Tracy Bellamy - Submission on Epping to Thornleigh Third Track - SSI 5132

Attention: Director – Infrastructure Projects
Epping to Thornleigh Third Track Project – SSI 5132

Submission on Epping to Thornleigh 3rd Track

Figure S.3 Cross-section and elevation - New Cheltenham Station concourse building

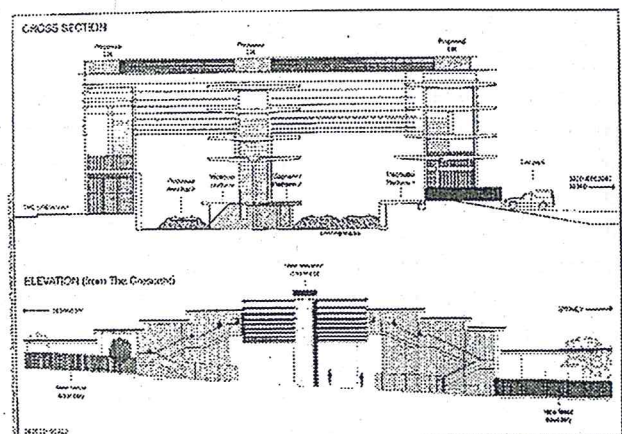
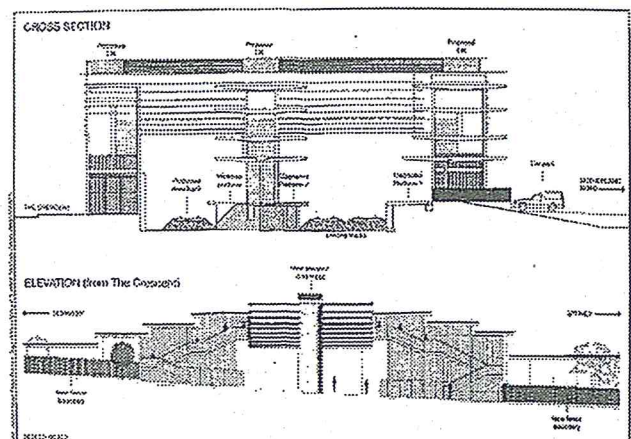
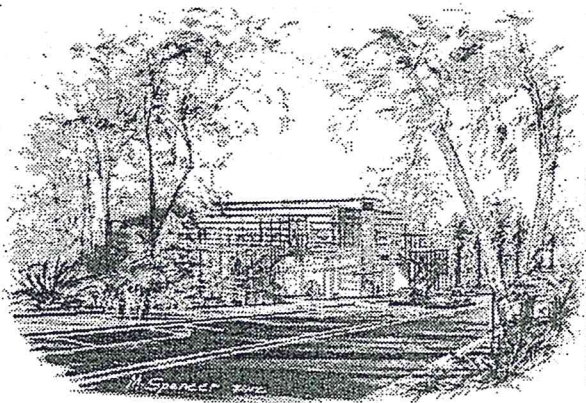
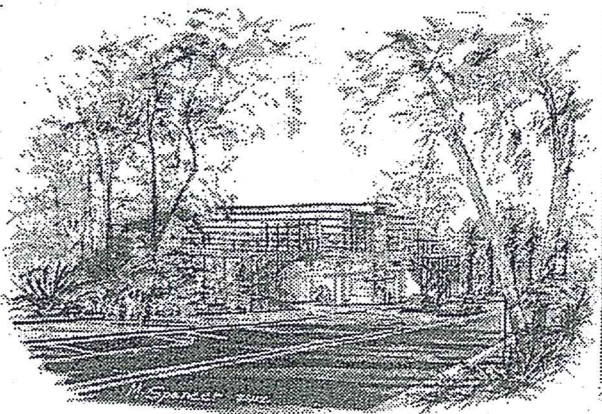
- The proposed design of the new station at Cheltenham is totally incompatible with the heritage conservation surroundings of the area. The existing low-lying brick station buildings are harmonious with the heritage conservation surroundings. By contrast, the proposed building (involving large panes of glass and a tall angular structure) would be completely at odds with the surrounds.
